**PLAN REVIEW SHEET**

**Petition #: RZP 2020-169**

**Request: UR-2 (CD)**

DEVELOPMENT STANDARDS

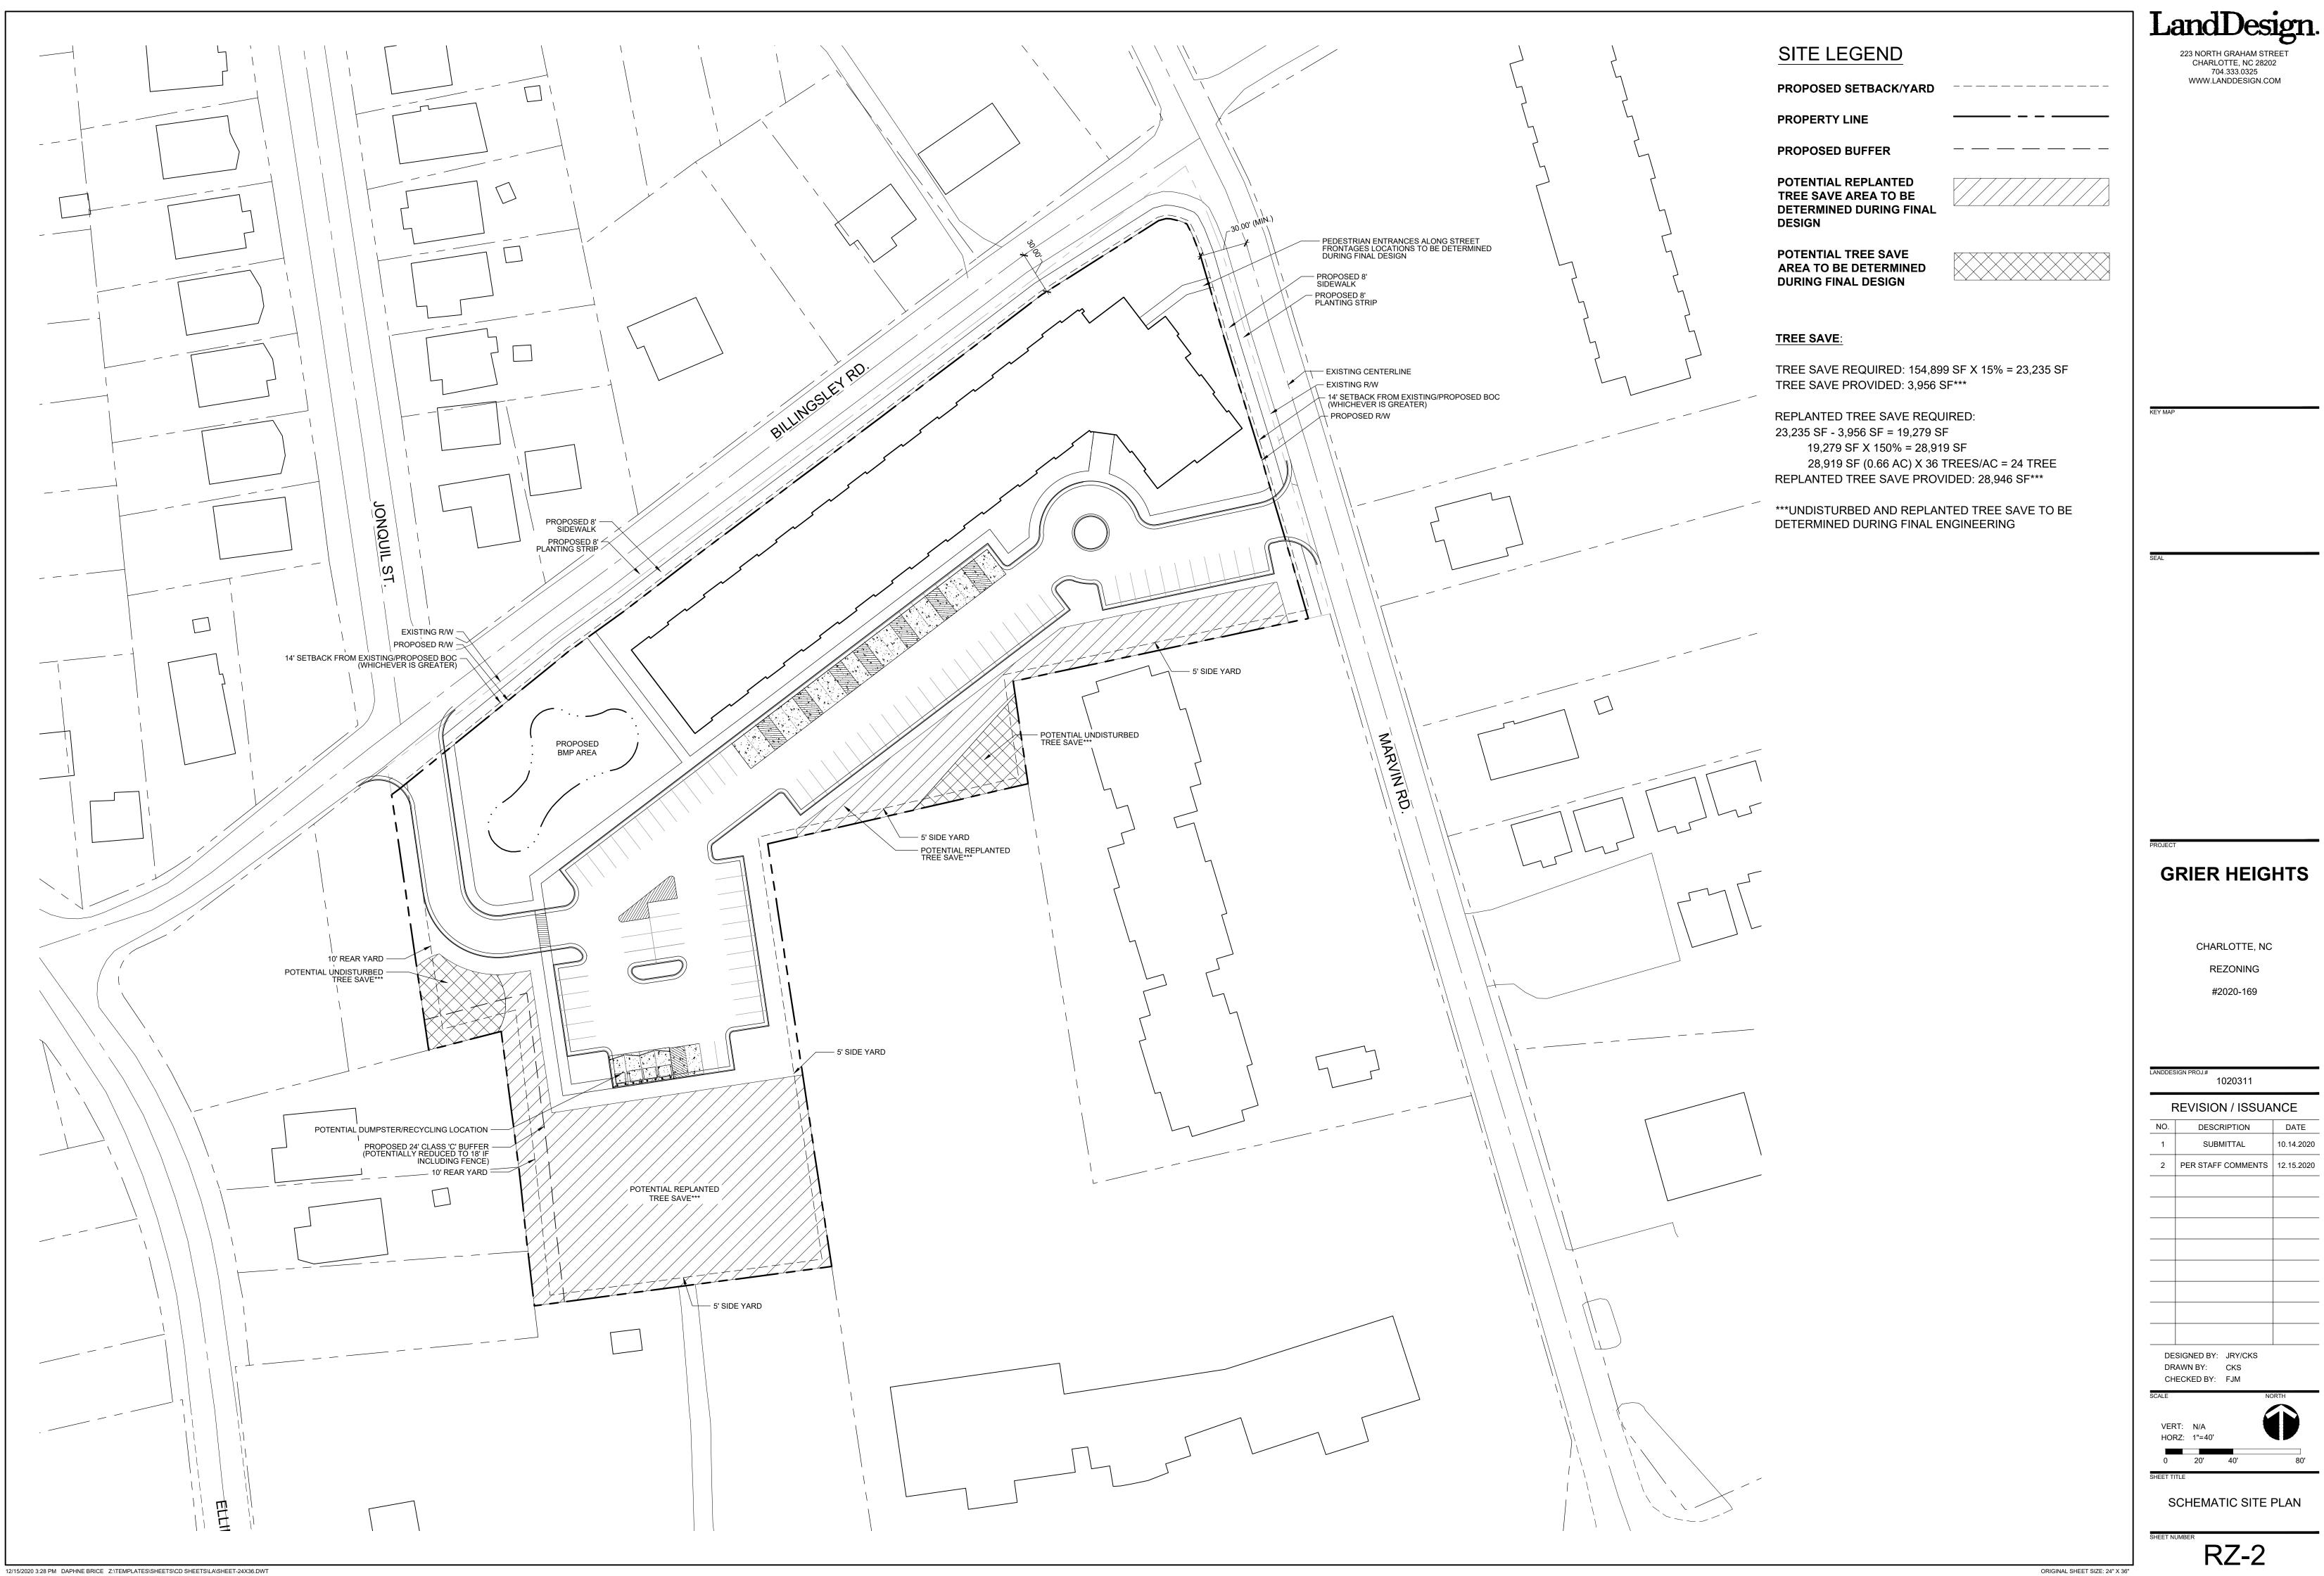
The site is located along CATS local bus route #39 on Billingsley Road. CATS requests the petitioner to construct a new ADA compliant bus waiting pad per Land Development Standard 60.01B near the location of the existing stop across the street. The final location of the pad will be coordinated with the developer through the permitting process.
